10 February 2020

Our Ref: R/2017/11/K
File No: 2020/058857

**Response to Additional Information for the Locomotive Workshop (Bays 5-15)
SSD 8449 MOD 4 – design and layout changes to the ground floor and Level 1 of
Bays 5-13**

③ SK_0851 GRID 8 GLAZING - GROUND FLOOR PLAN
1:50

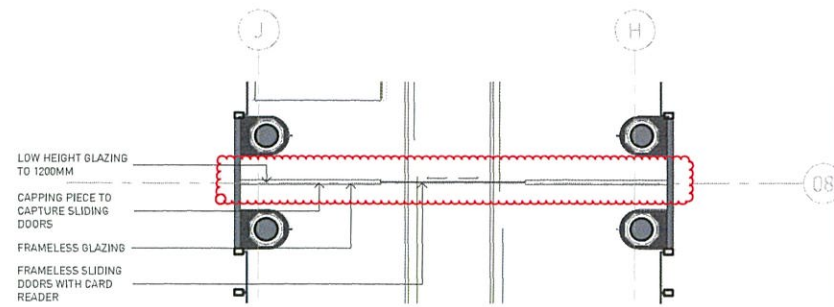
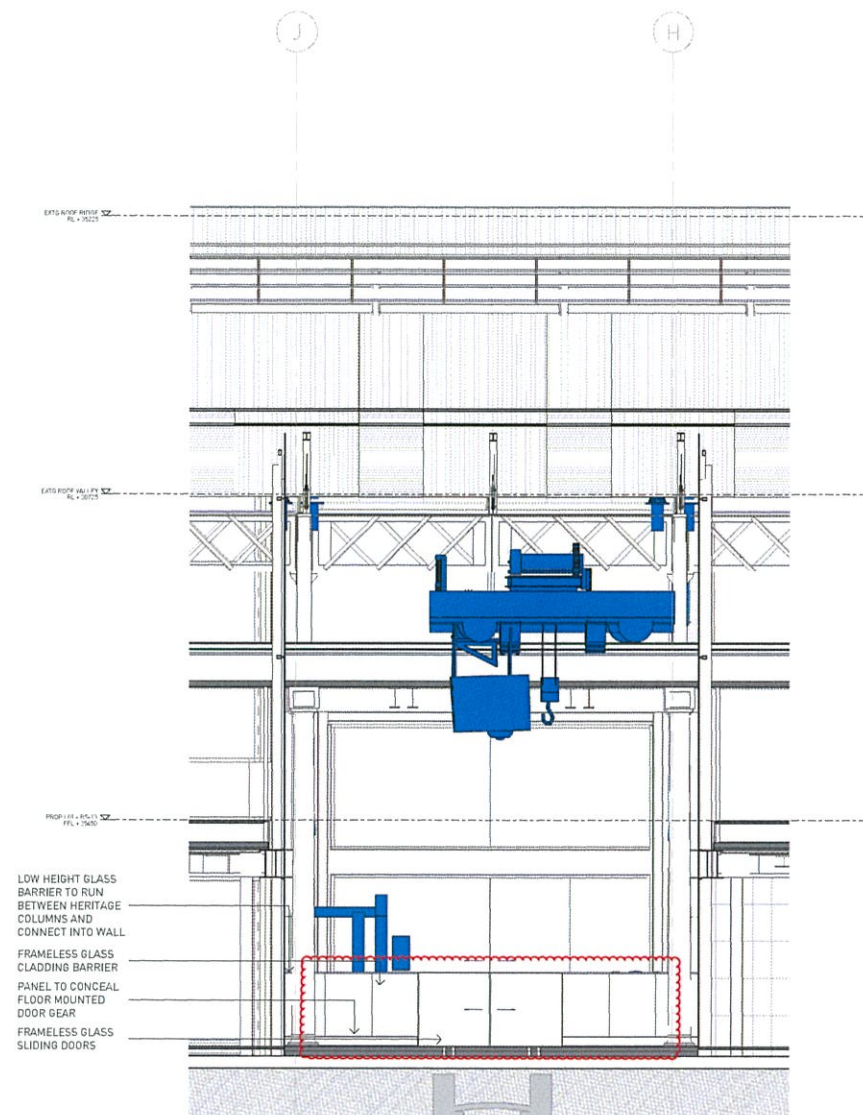
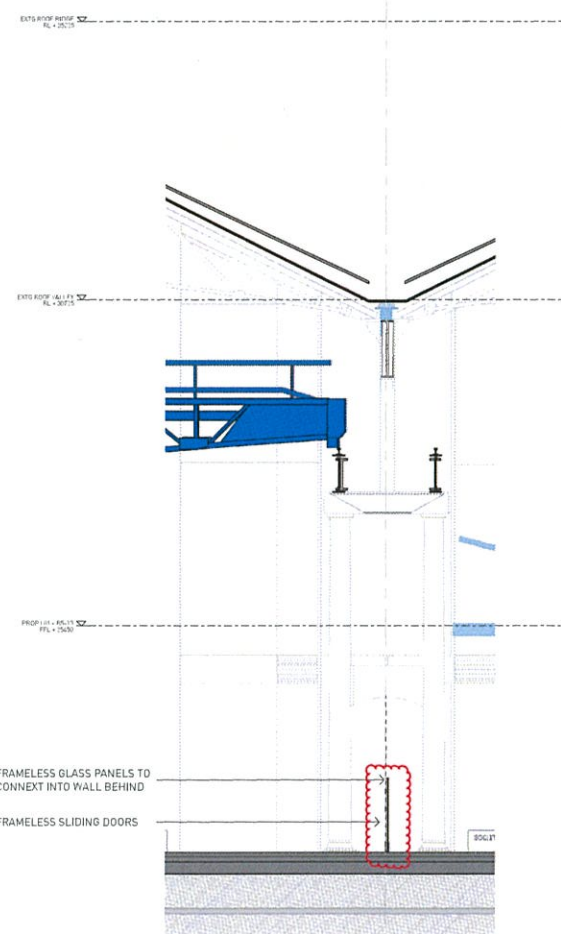
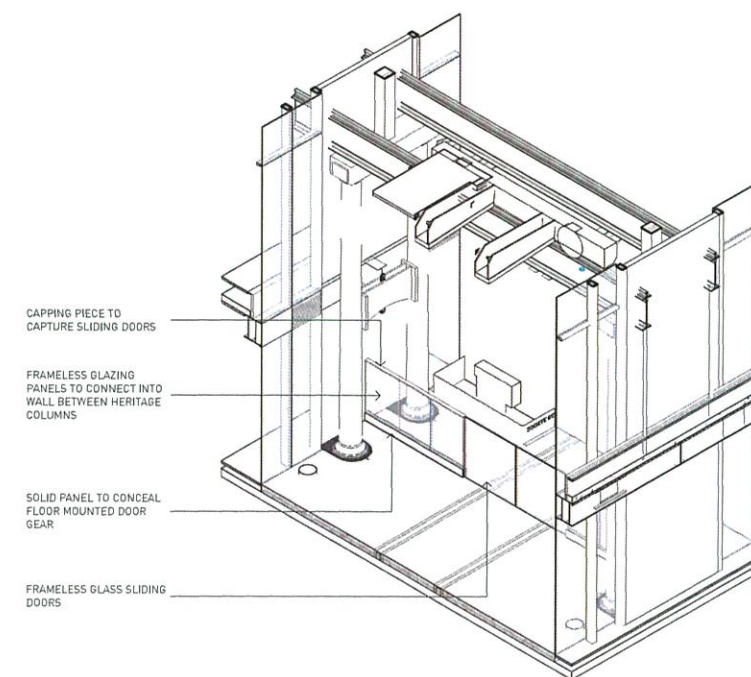
Thank you for your correspondence dated 4 February 2020 requesting for the City of Sydney Council ("the City") to comment on the additional information submitted for MOD 4 of SSD 8449. Specifically, the information seeks to address the issue raised regarding the provision of a sliding door along Gridline 8 of the Locomotive Workshops, as expressed in the City's letter dated 13 December 2019.

The supporting documentation has been reviewed. The City accepts the requirement of the sliding door at Gridline 8 to ensure public safety and fire compliance under the BCA. The alternative proposal for a low height frameless glass barrier would maintain the visual continuity of the corridor and is a reasonable outcome for the circumstance of the development.
